From: Ross Leal
Sent: 05 February 2018 16:02
To: Planning.Responses
Subject: FW: Acknowledgement of new application M/116/17/CLP - Your ref: N/A

From: Ross Leal
Sent: 05 February 2018 16:02
To: [REDACTED]
Subject: RE: Acknowledgement of new application M/116/17/CLP - Your ref: N/A

Proposed Elevations

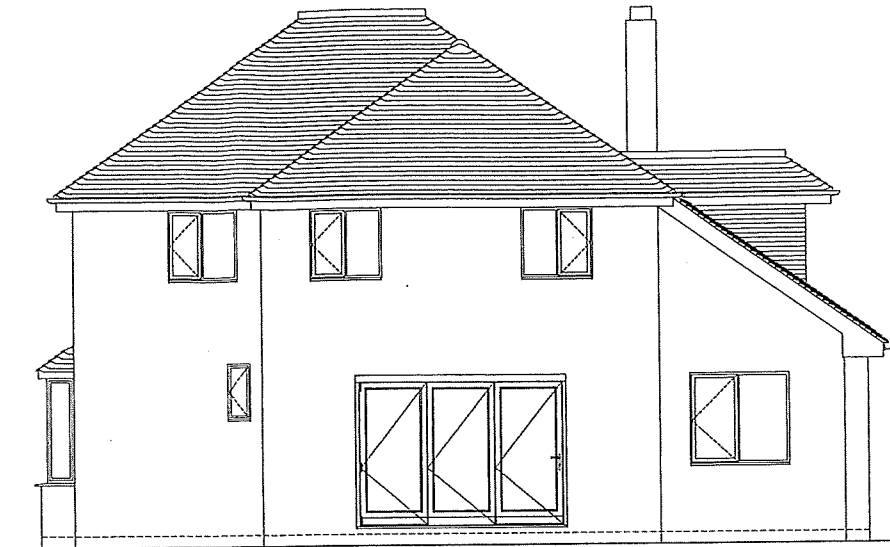
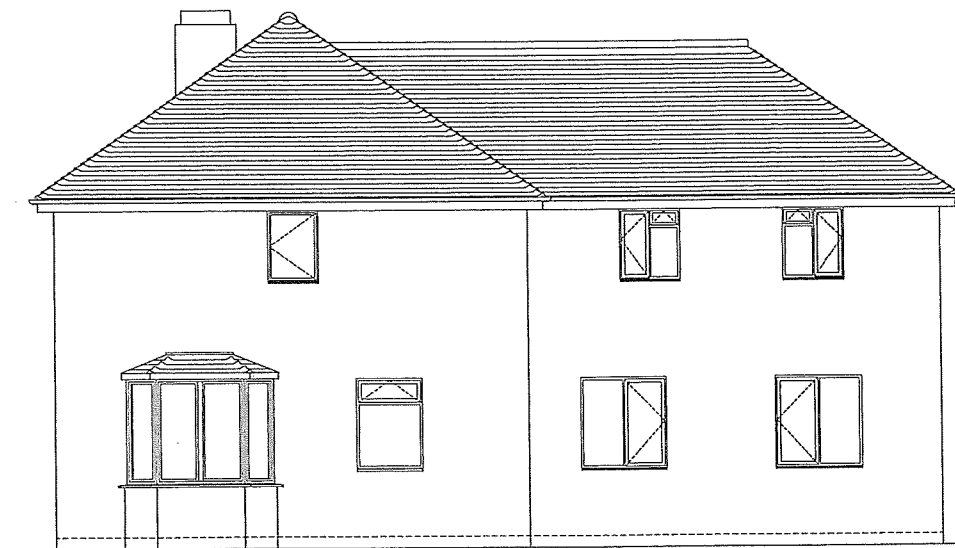
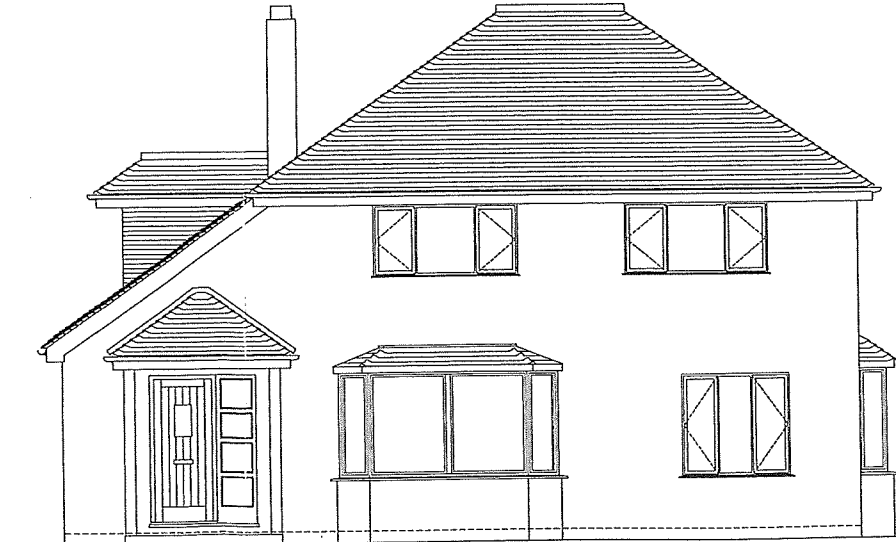
1. You have not specified whether materials are to be matching/similar to existing. In order for to grant a Certificate, the proposed materials must be matching/similar to existing. Please confirm the position.
2. In order not to require planning permission, the glazing on the 2 windows in the extended/replacement dormer must be permanently obscure glazing. The windows must also not have any parts which can be opened which are more than 1.7 metres above the floor of the room in which the window is installed. This is not apparently the case in your application. Please confirm what is proposed.
